**From:** Caroline Ford  
**Sent:** 11 September 2019 12:56  
**To:** DC Support  
**Subject:** FW: Bicester Gateway Business Park- Compound and enclosure for siting of LPG Tanks

Please record and register onto 19/01600/F

**From:** Megan Mount <Megan.Mount@cherwell-dc.gov.uk>  
**Sent:** 11 September 2019 12:49  
**To:** Caroline Ford <Caroline.Ford@Cherwell-DC.gov.uk>  
**Subject:** Bicester Gateway Business Park- Compound and enclosure for siting of LPG Tanks

01 SITE SETTING OUT MASTER Copy 1  
1:50

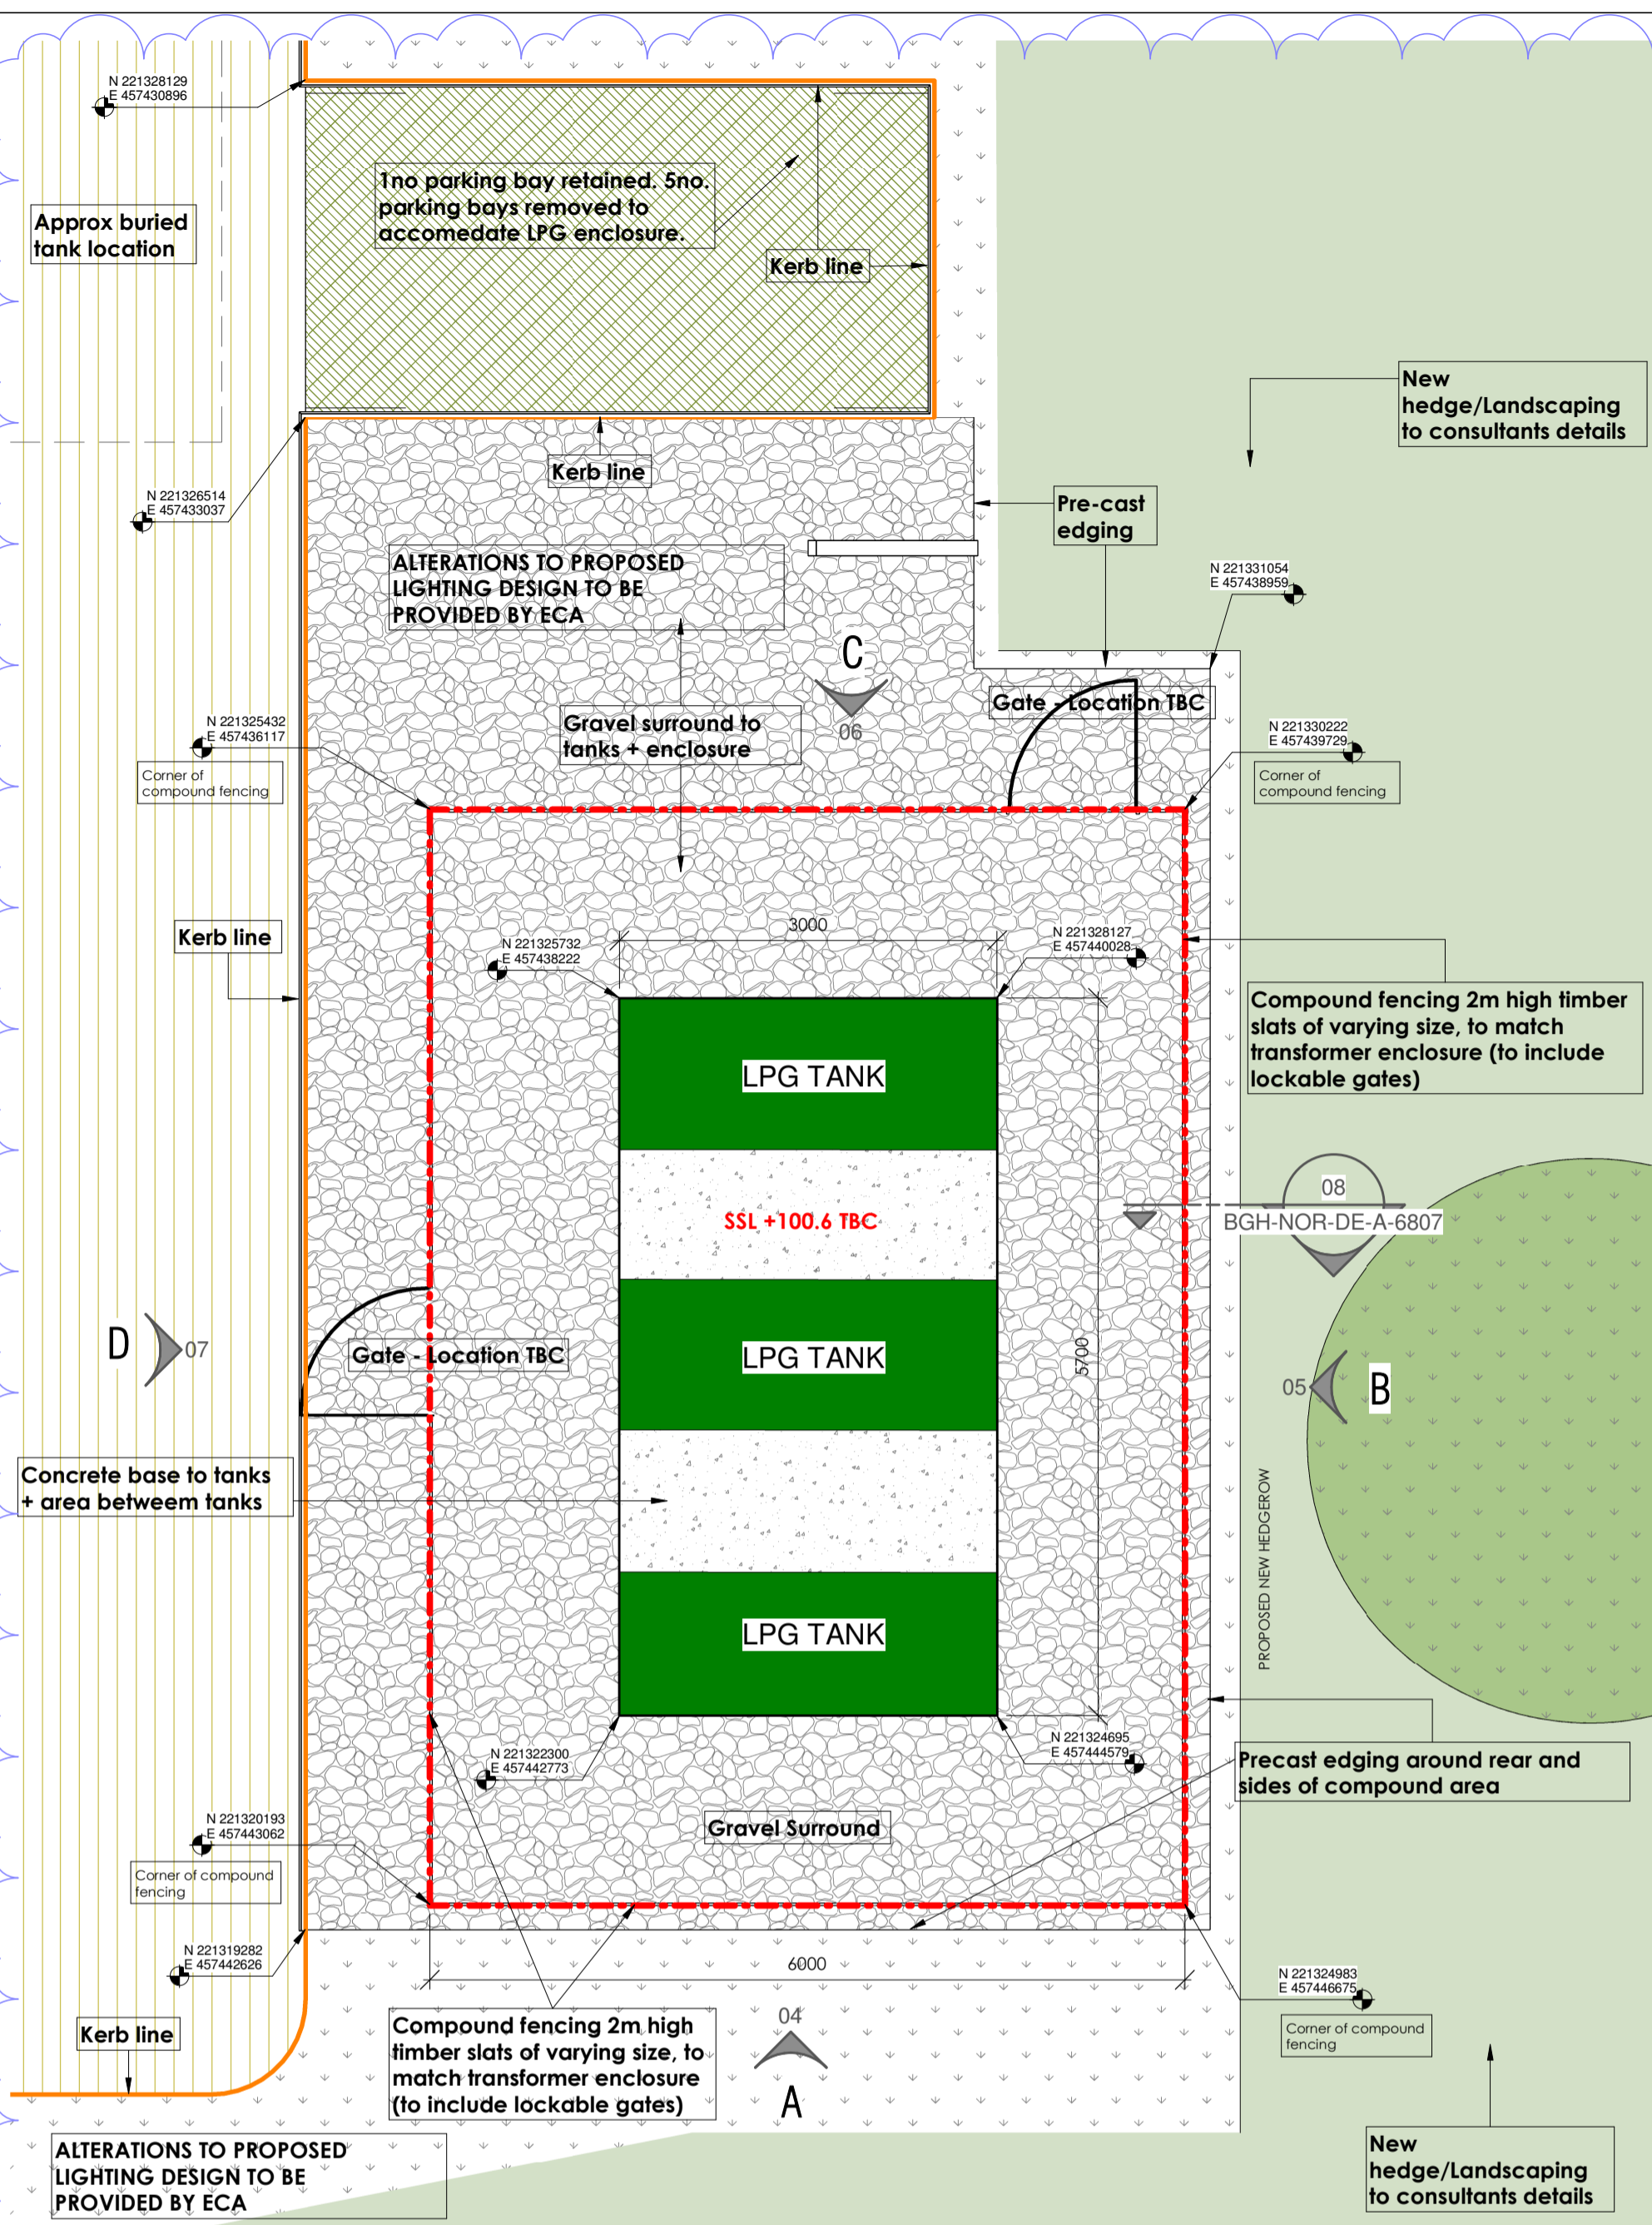
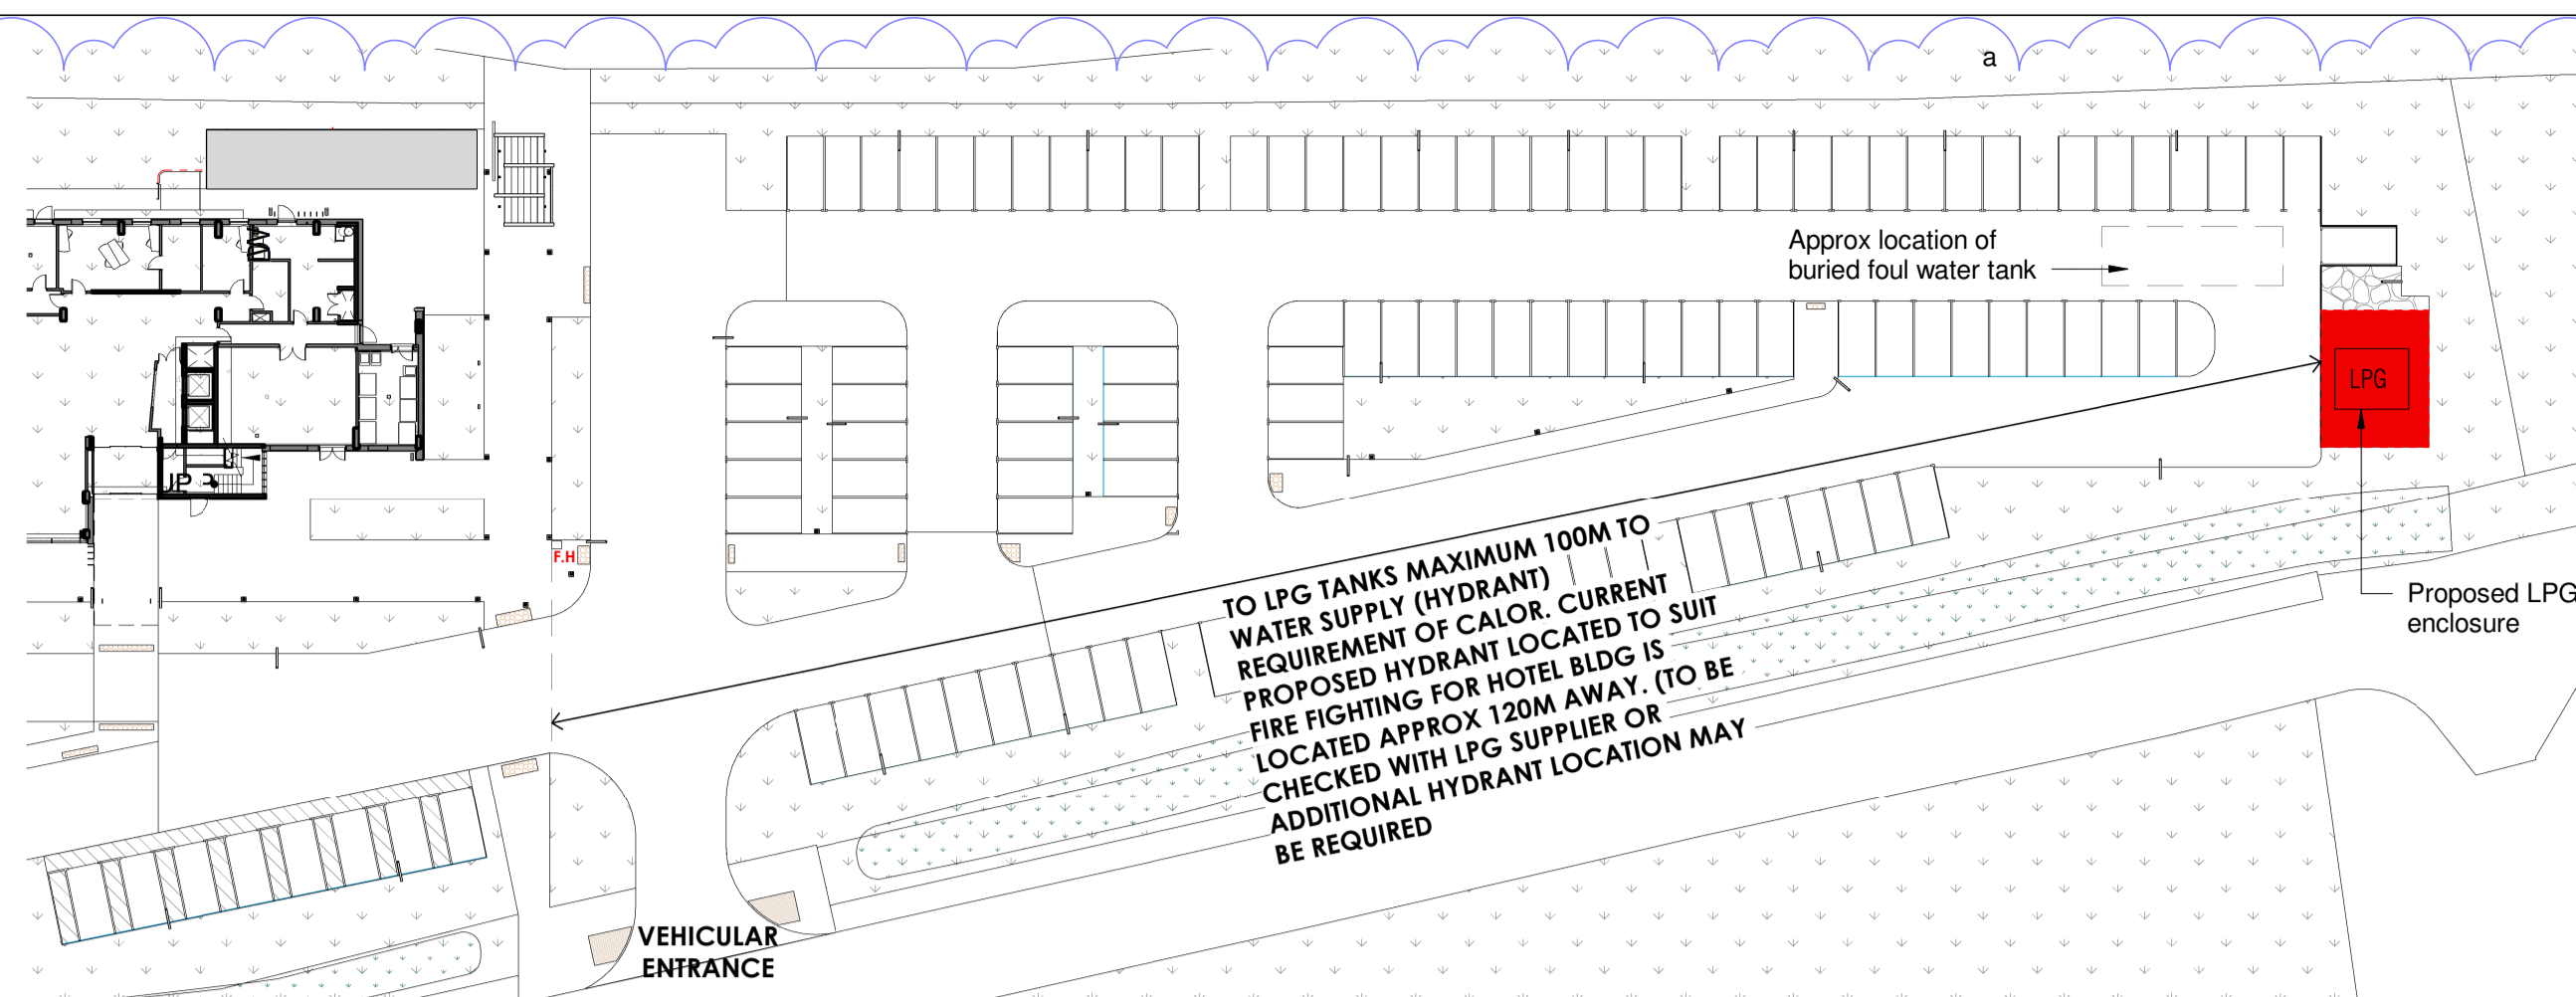
- Ensure the tanks are not sited near trees or vegetation
- Ensure protection from impact. i.e. underground tanks are not placed below areas where vehicle movement is likely
- Good ventilation is maintained around the tanks
- Ensure there are no open drains (unless fitted with water trap), culverts etc within the separation distance.
- Suitable separation from boundaries, buildings, fixed sources of ignition (including overhead power lines)
- Adequate separation from other tanks and positioned such that integrity is not compromised.
- Standing on stable base
- No combustible materials within separation distance.
- Suitable security to prevent access by the public.
